Your ref: PAE-89057722
Our ref: DOC25/617149-33

Re: Huntlee New Town - Stage 2 (SSD-70748466) – Response to Submissions

Attachment 1 - CPHR Comments on Huntlee New Town - Stage 2 (SSD-70748466) – Response to Submissions

Figure B1 [B]
Developed Case Local
Model
0.5 EY Flood Elevation
and Depth

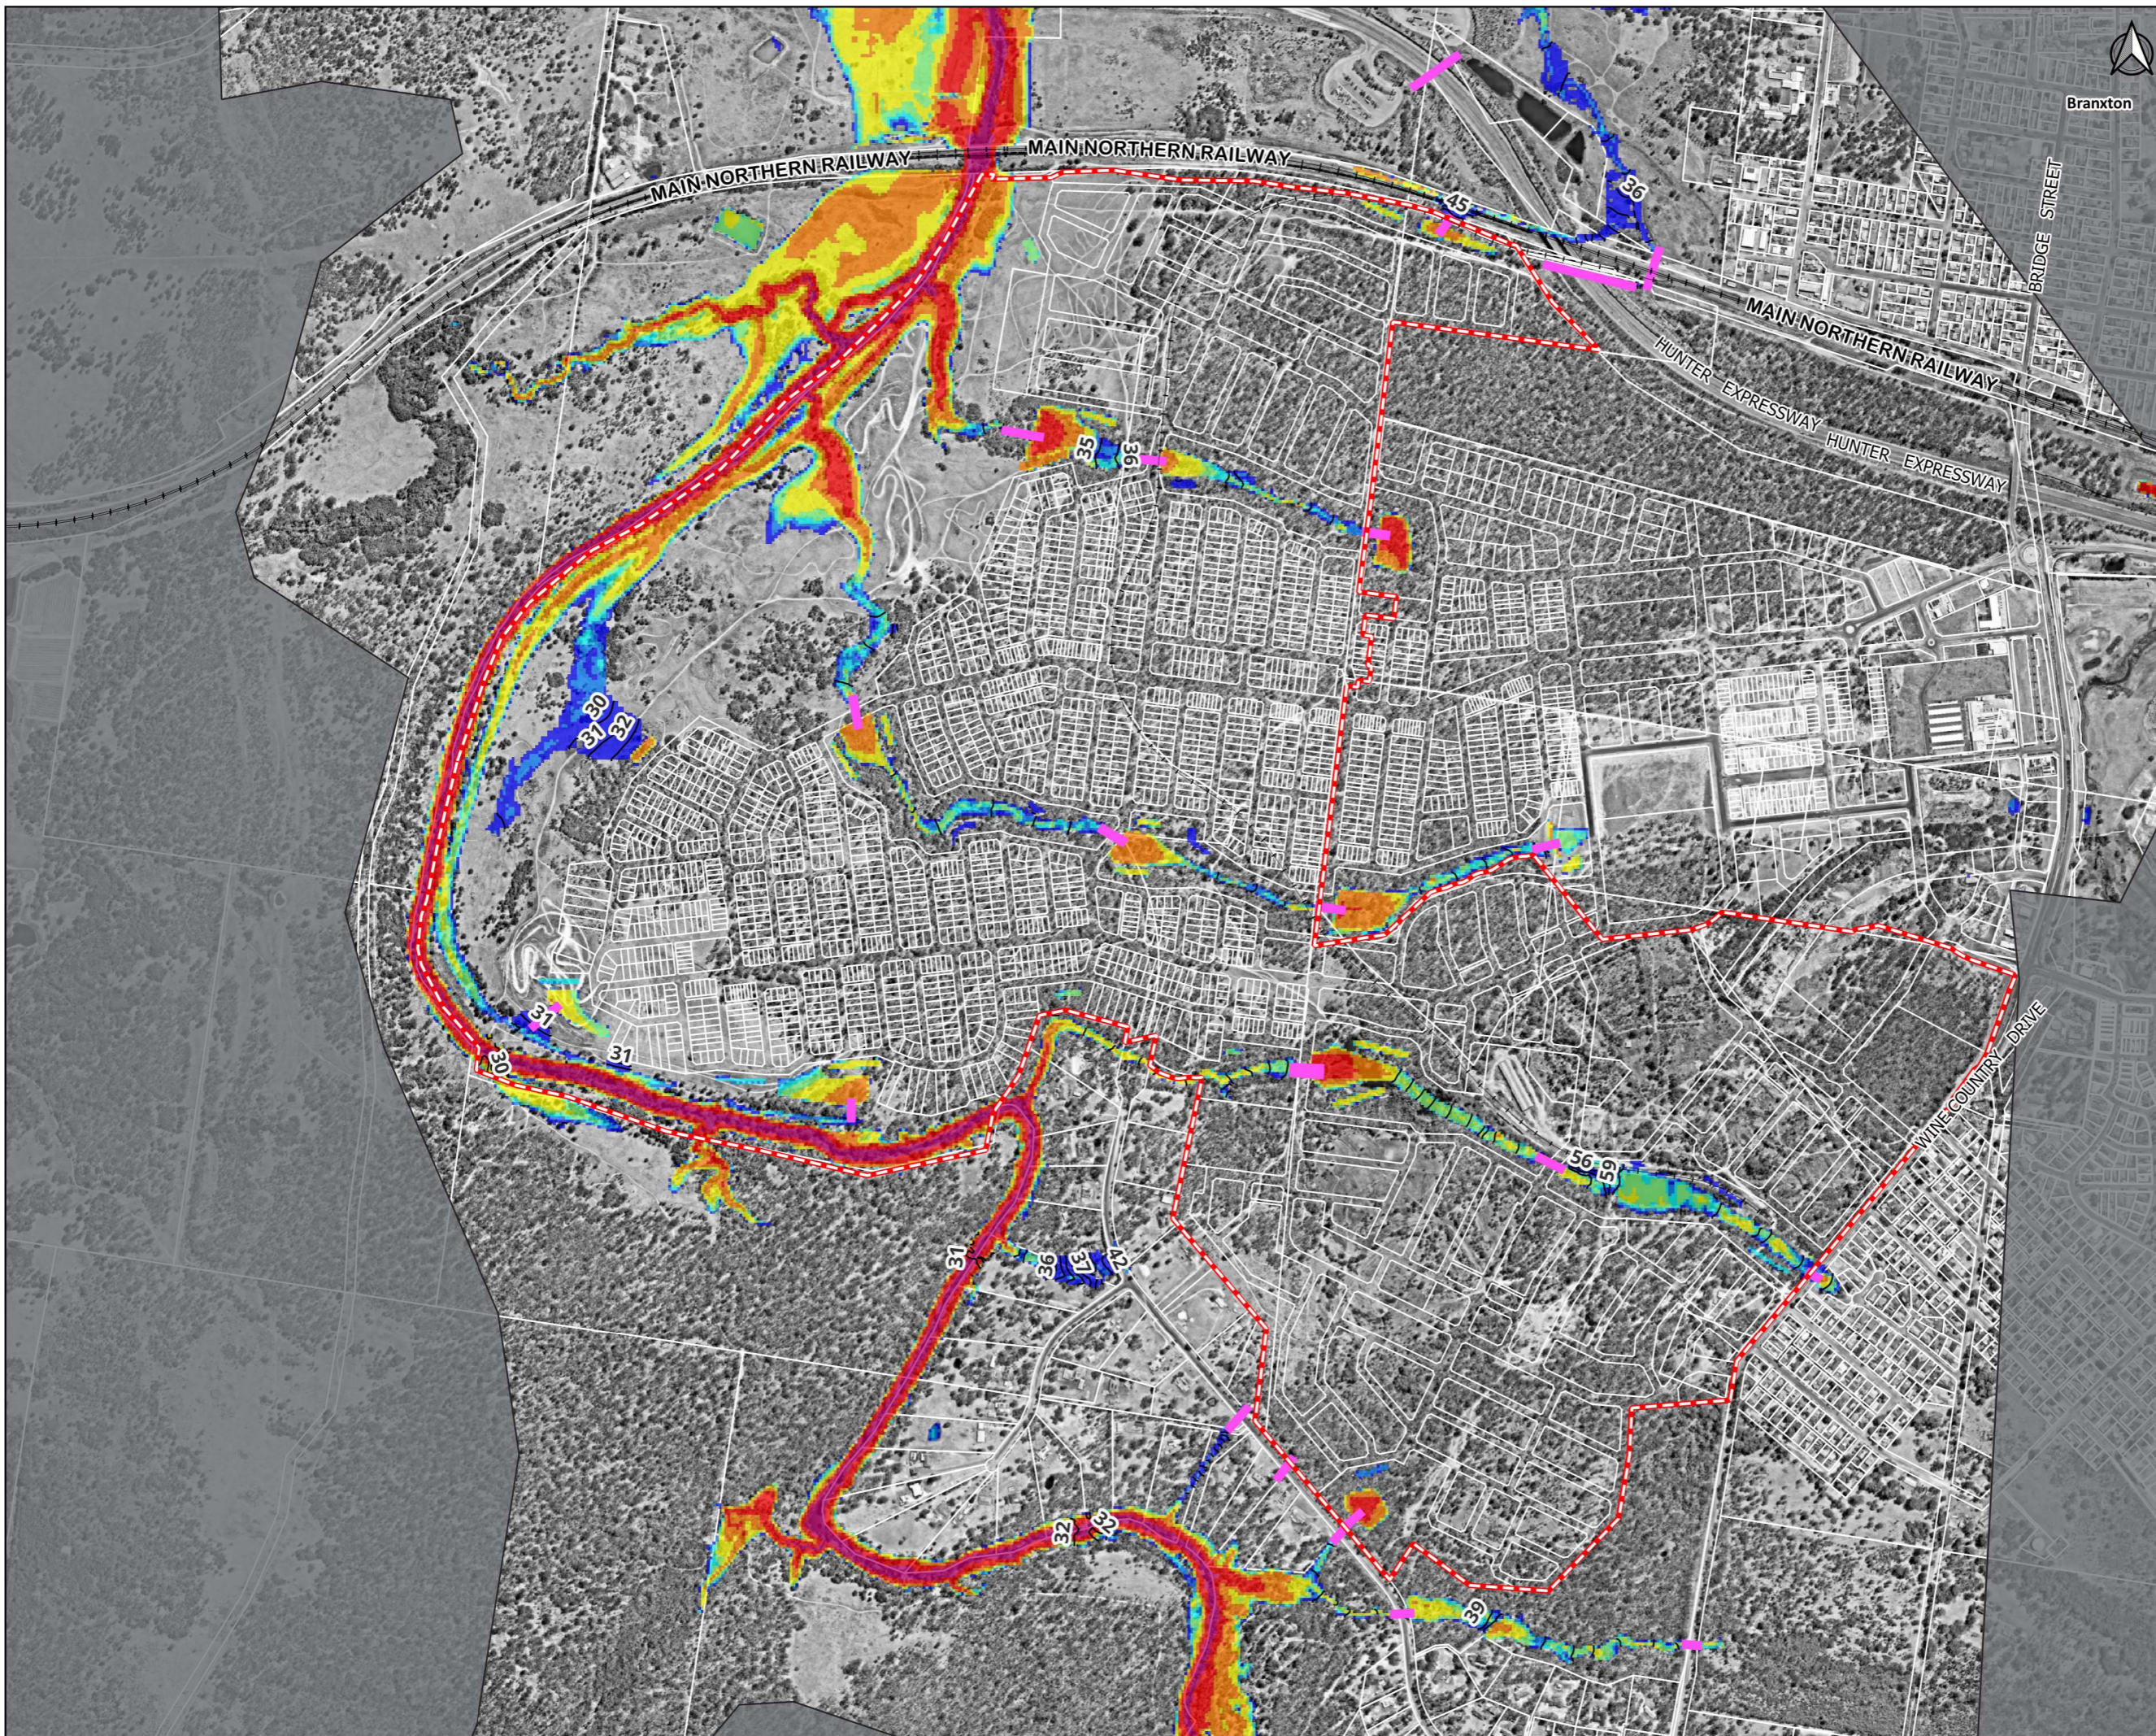
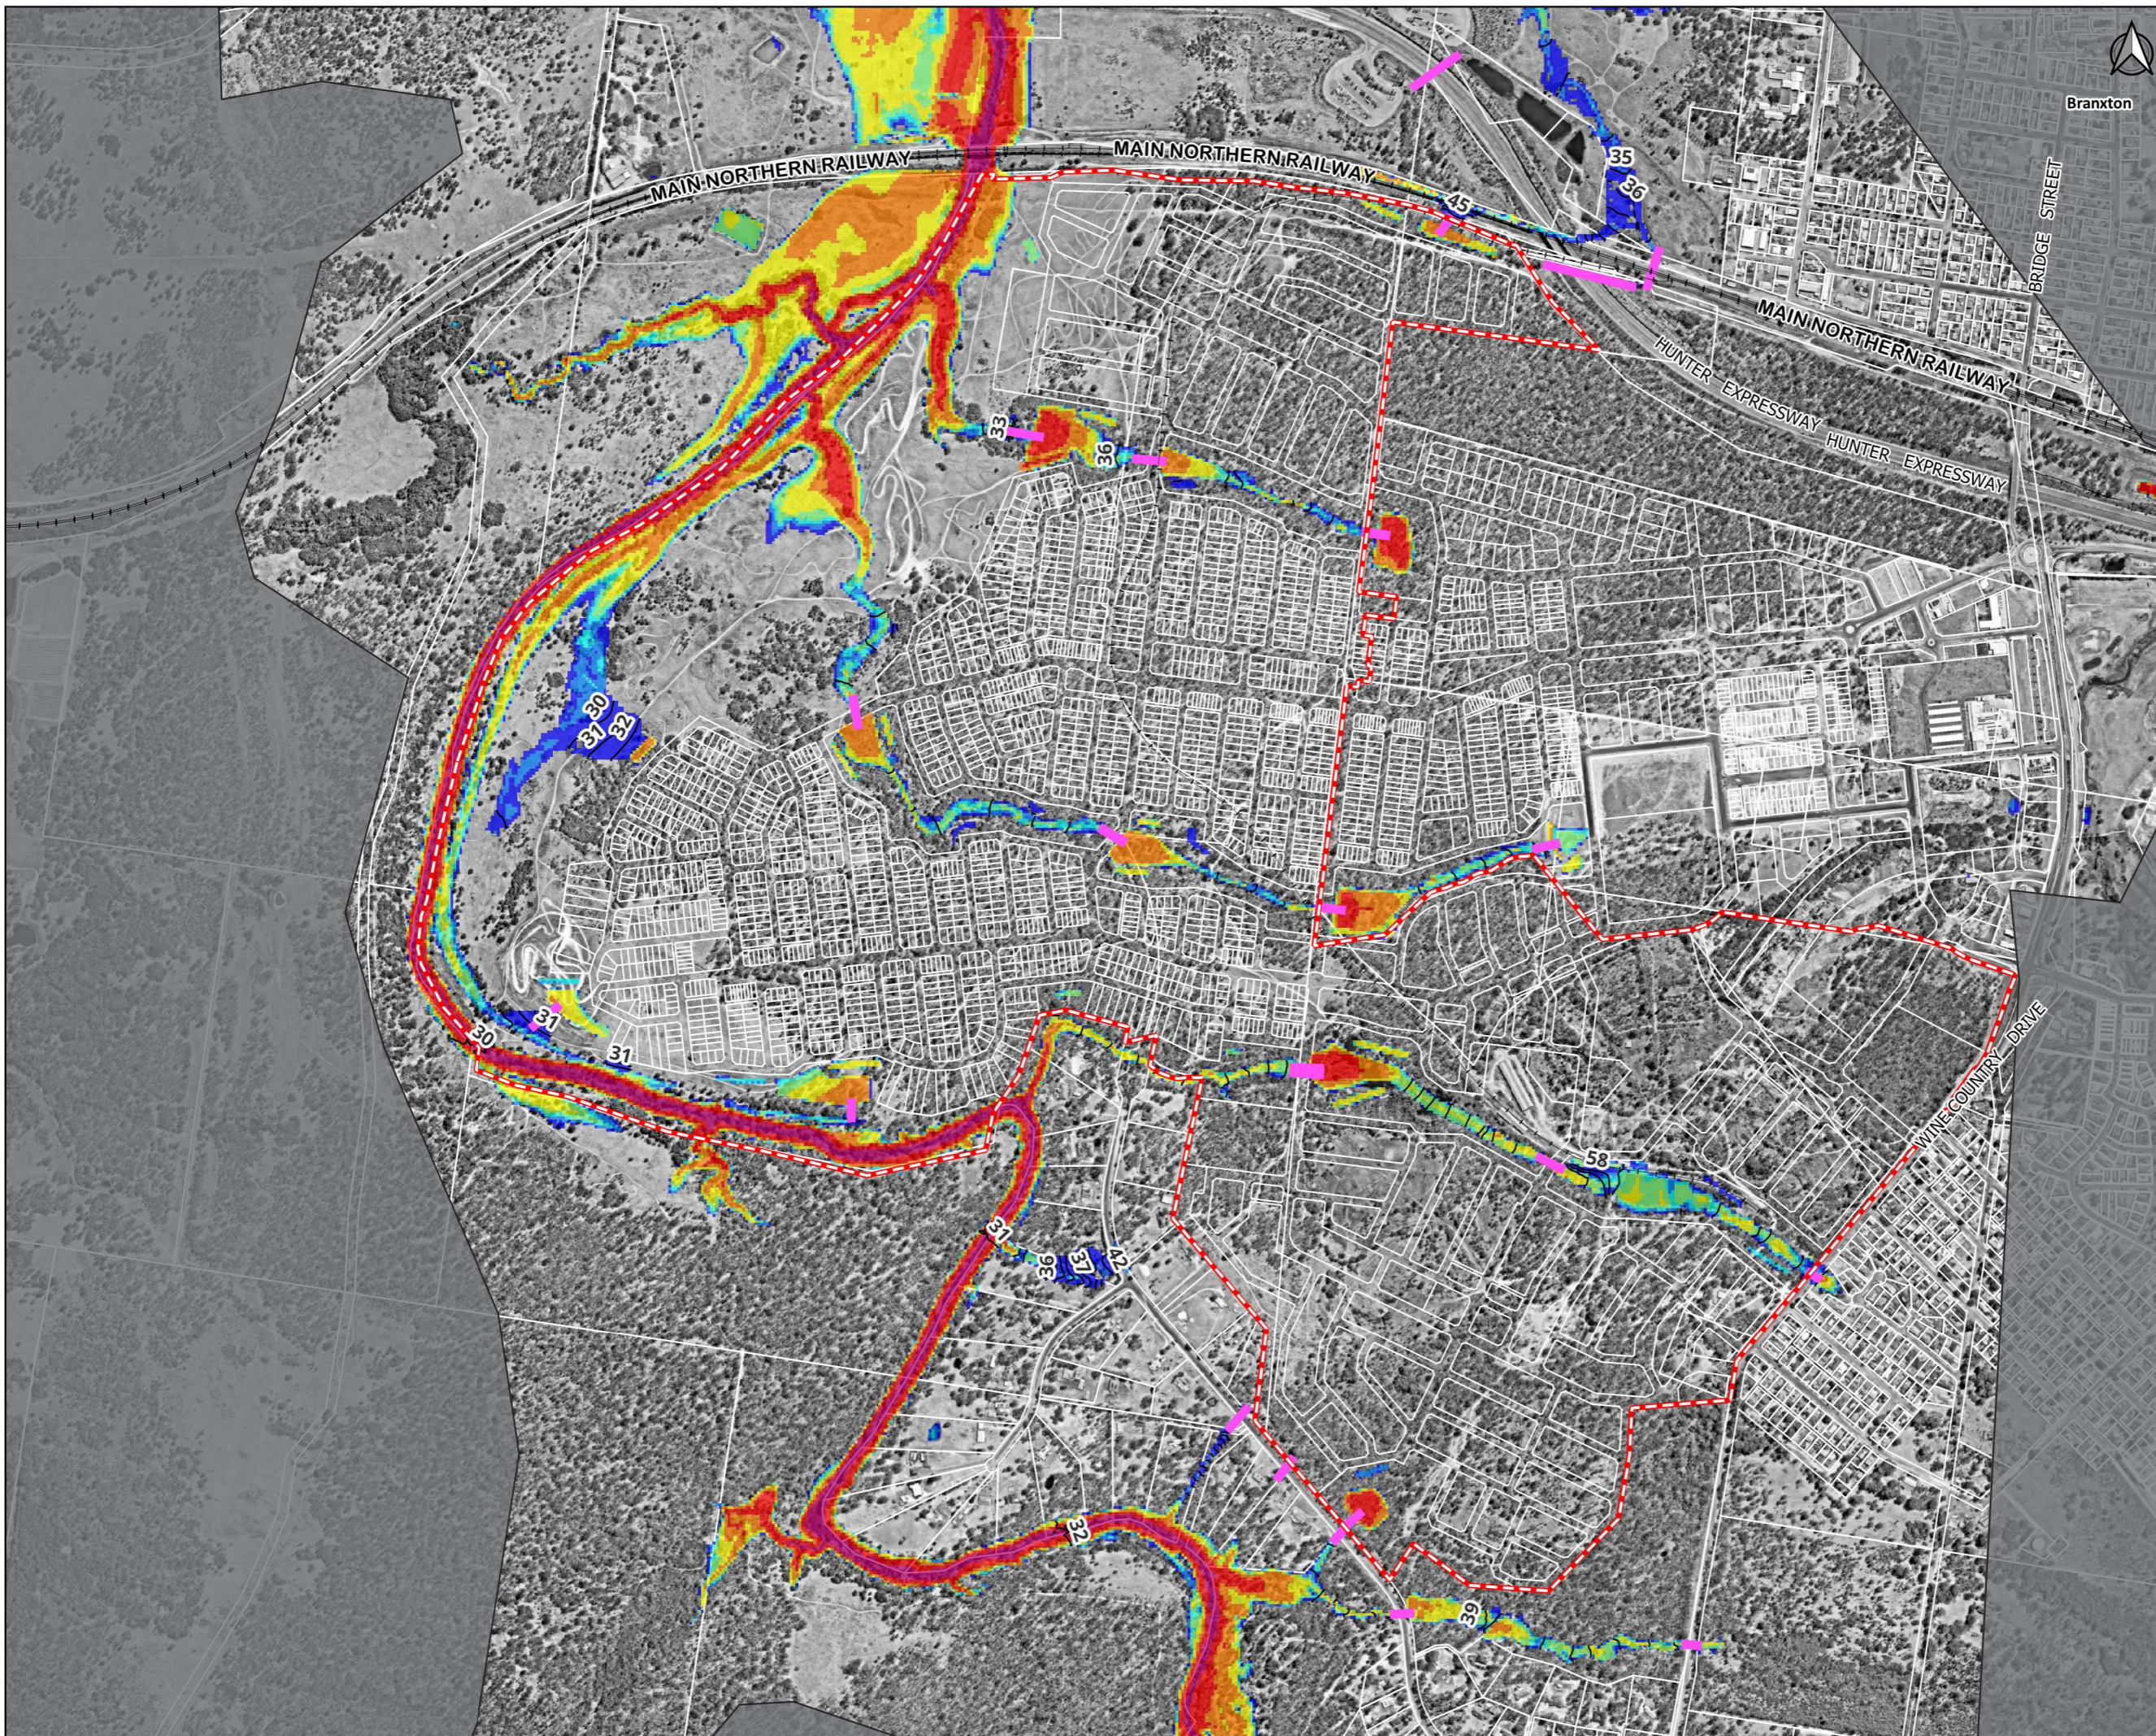
CPHR Issue 15	The sensitivity of structure blockage factors should be assessed for developed case flood conditions.
	Note this is an old issue that has not been addressed. Structure blockage factors, determined in accordance with Australian Rainfall and Runoff Guidelines 2019, have been adopted for modelling of design flood conditions for the developed case. Consideration of higher blockage factors should be undertaken as a sensitivity assessment for the range of design events, to ensure freeboard at road crossings is appropriate. Additionally, higher blockage factors at key drainage infrastructure may increase flows across lots and roadways during larger local catchment flood events (1% AEP or rarer). The impact on flood emergency management, including extent of possible inundation, warning time and road trafficability needs to be understood. In addition to increase in peak flood levels along existing flow paths, Figure 91 of the EIS must also indicate the increased inundation extent due to blockage. Impact maps should be updated to include “was dry, now wet” extents to determine if flood impacts are expected to extend to lots or roadways.

Recommendation	Blockage of drainage structures should be considered as a sensitivity for developed case flood conditions, including the impact on flood emergency management. Flood impact maps should be updated to include “was dry, now wet” extents.
Recommended Conditions of Approval	TBA
